**Project# 1006844**

**NAME:** LANDS OF LUTHERAN CHURCH IN AMERICA

**CITY OF ALBUQUERQUE  
PLANNING DEPARTMENT  
July 15, 2015  
DRB Comments**

**RE: Lot A-1, Lutheran Church in America**

PLAT FOR  
TRACT A-1-A & A-1-B  
LUTHERAN CHURCH IN AMERICA  
WITHIN  
SECTION 30  
TOWNSHIP 11 NORTH, RANGE 4 EAST, NMPM  
CITY OF ALBUQUERQUE  
BERNALILLO COUNTY, NEW MEXICO  
JULY 2015

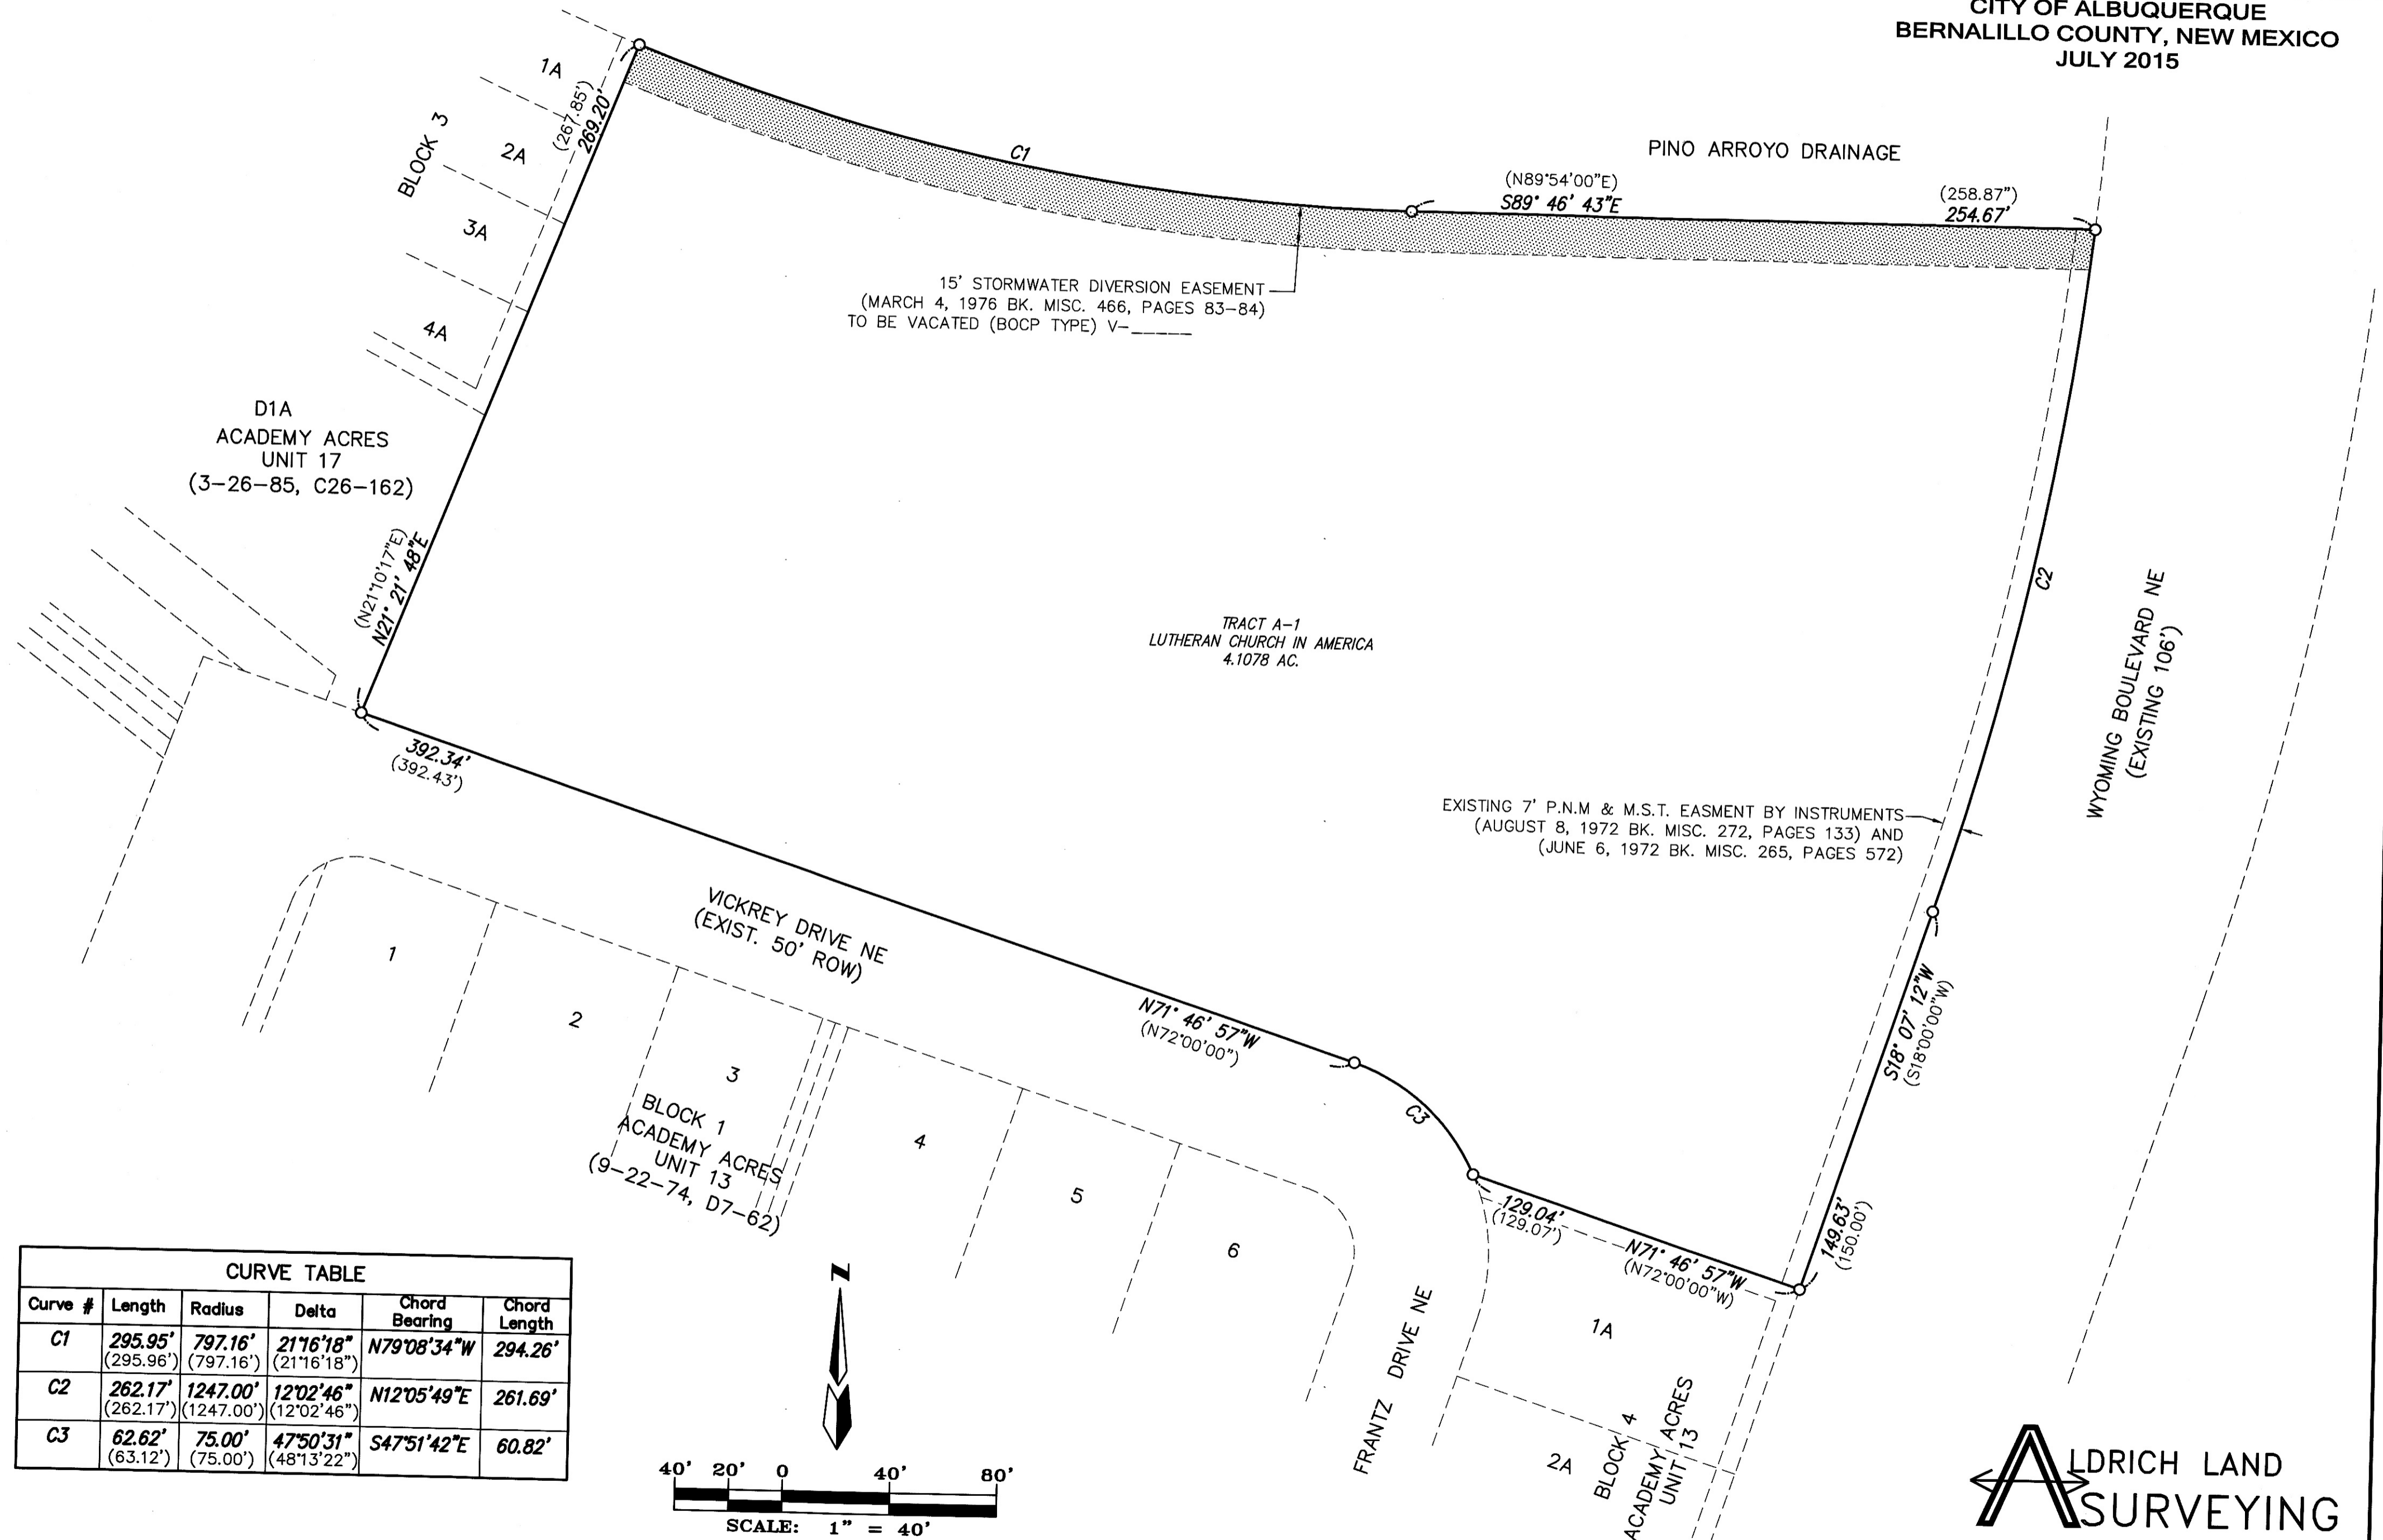
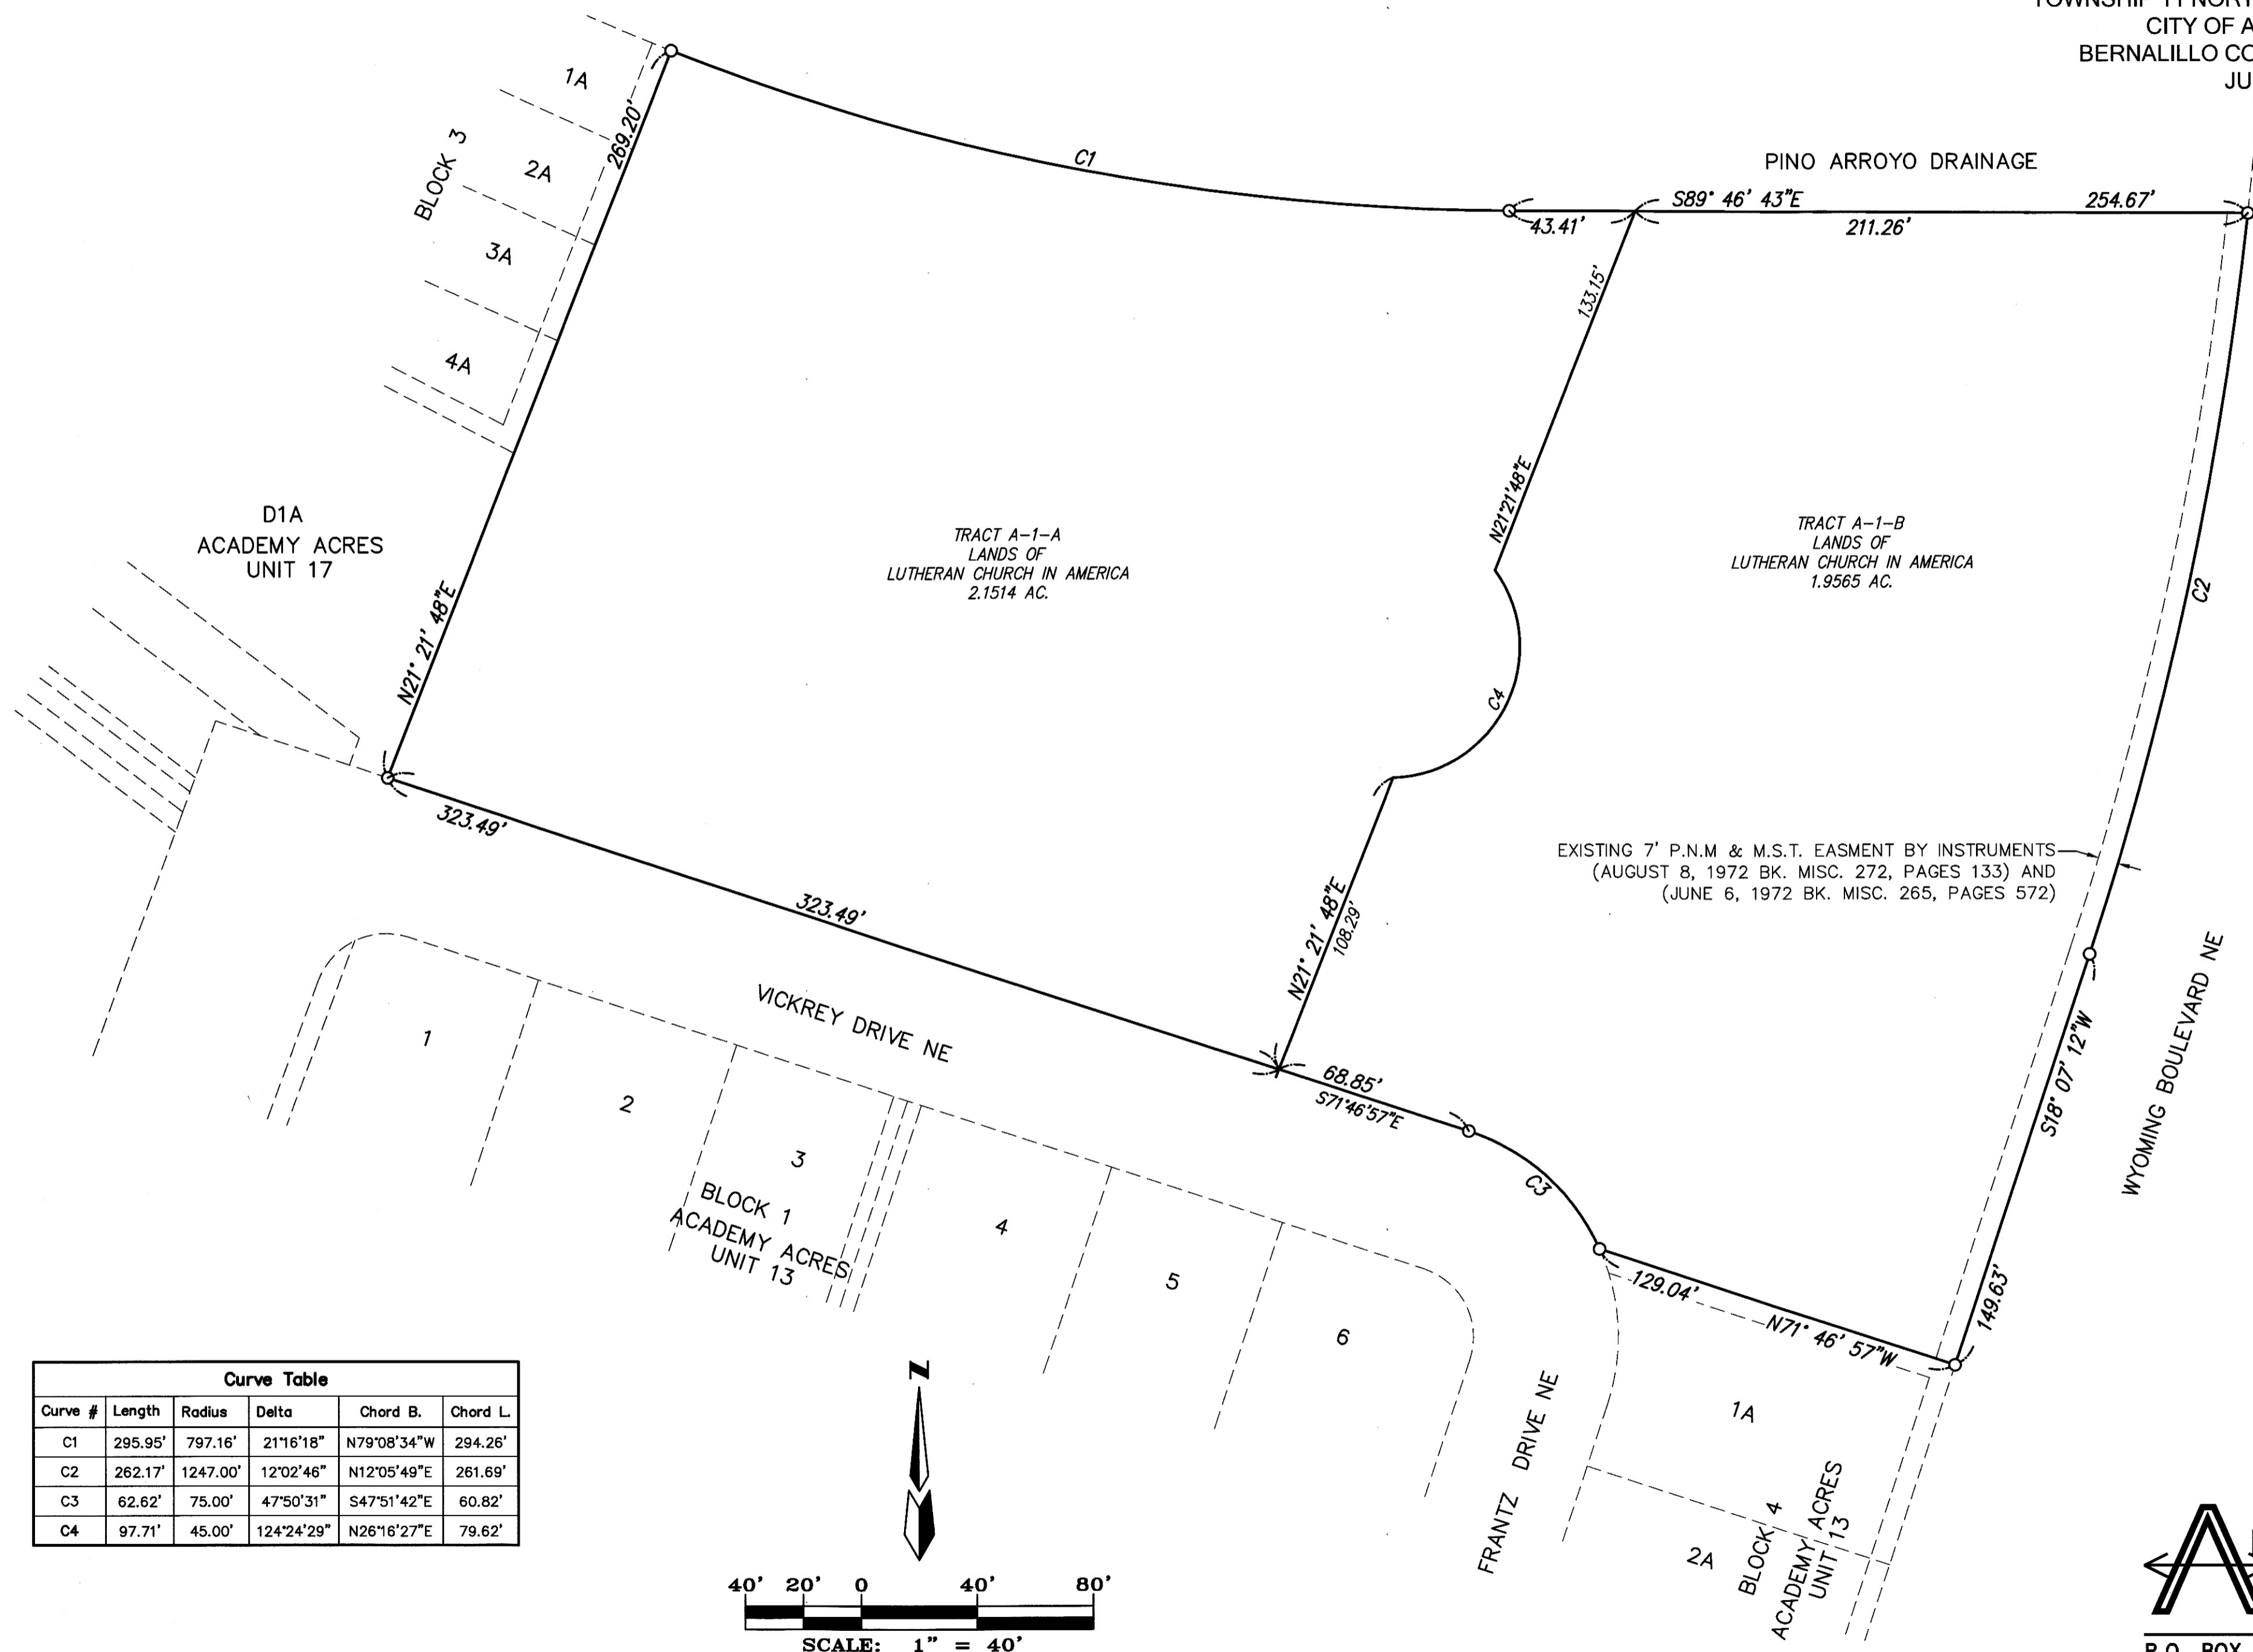
The amended Site Plan for Building Permit 15EPC-40017 must be submitted for DRB sign-off prior to/ or concurrent with/ the plat to create two lots.

A Bulk Land Variance is not appropriate, as the only infrastructure required with the two lot plat will be a sidewalk for Vickrey Drive; the "Notice of ..Variance" note can be removed.

For the townhomes layout, the property line for proposed Lot 9-P1 needs to be far enough east to allow for full driveway access.

SKETCH PLAT FOR  
LANDS OF  
LUTHERAN CHURCH IN AMERICA  
WITHIN  
SECTION 30  
TOWNSHIP 11 NORTH, RANGE 4 EAST, NMPM  
CITY OF ALBUQUERQUE  
BERNALILLO COUNTY, NEW MEXICO  
JULY 2015

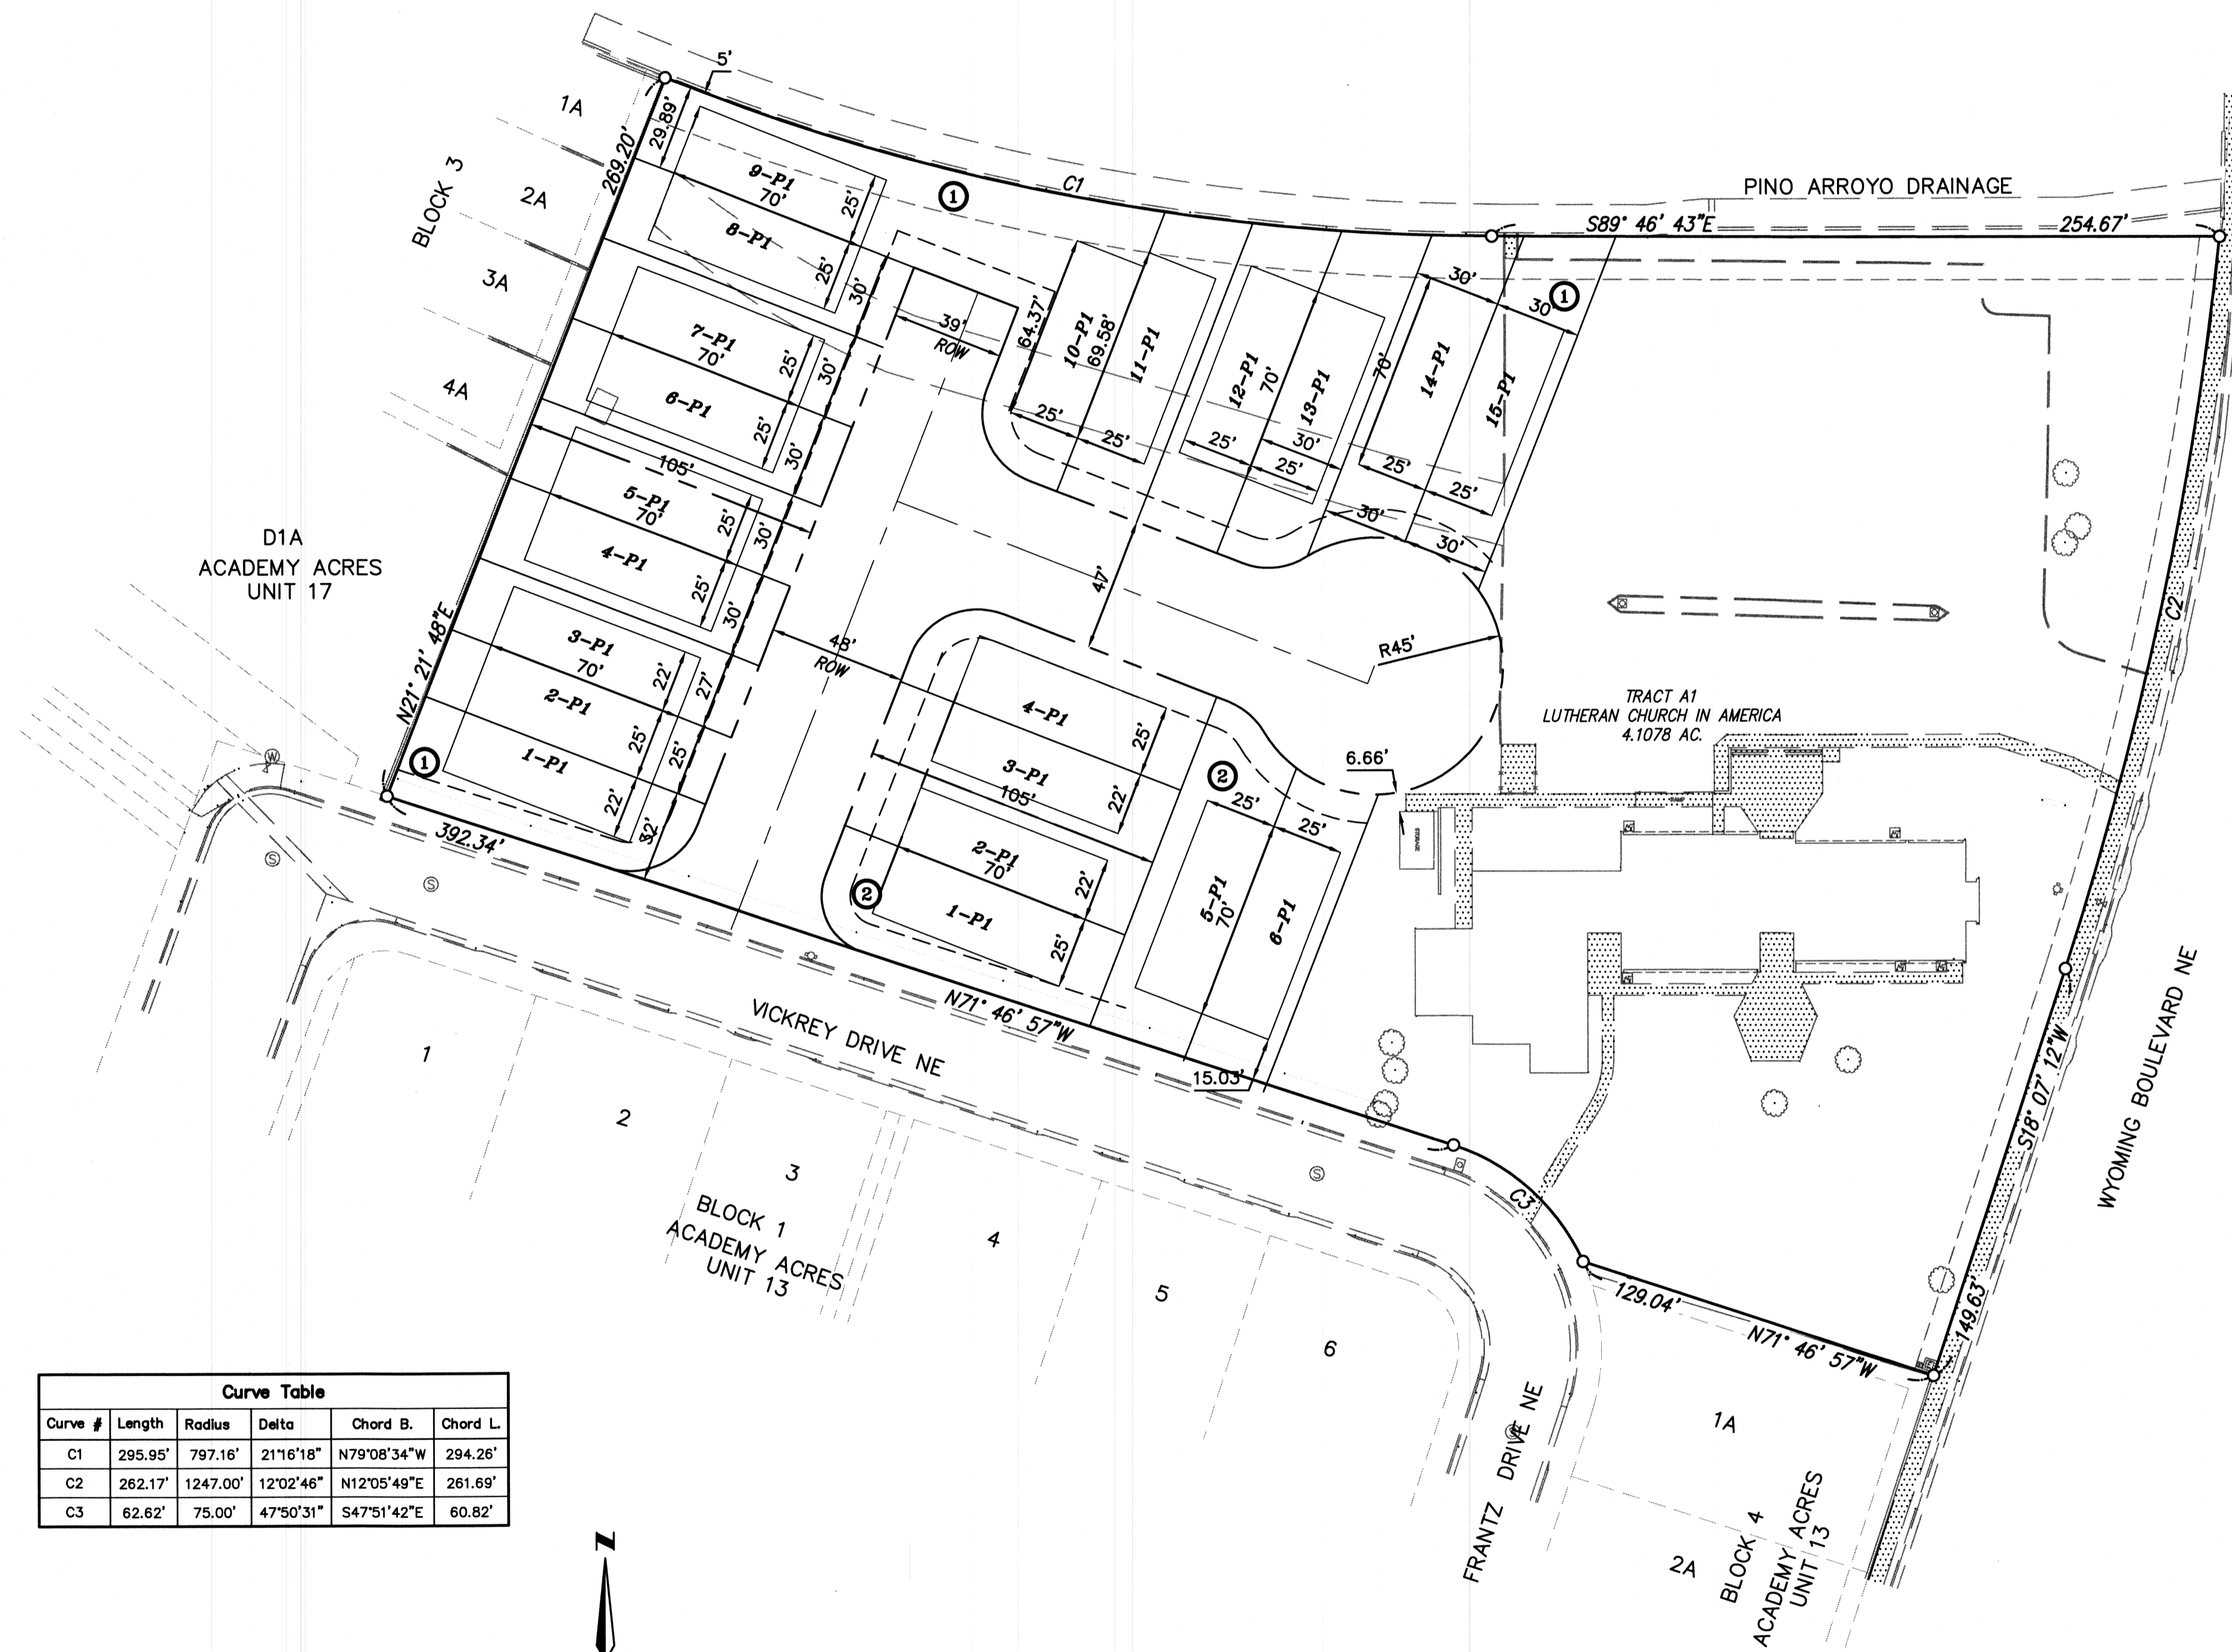
<u>No.</u>	<u>Comment</u>
1)	A cul-de-sac is required at the end of the east stub due to the number of lots being served.
2)	With a 49' r/w and the narrow lots, these should be P1 designated.
3)	A cross section of Vickrey Drive is needed to evaluate infrastructure requirements and possible dedications.
4)	Standard infrastructure per the DPM is required.
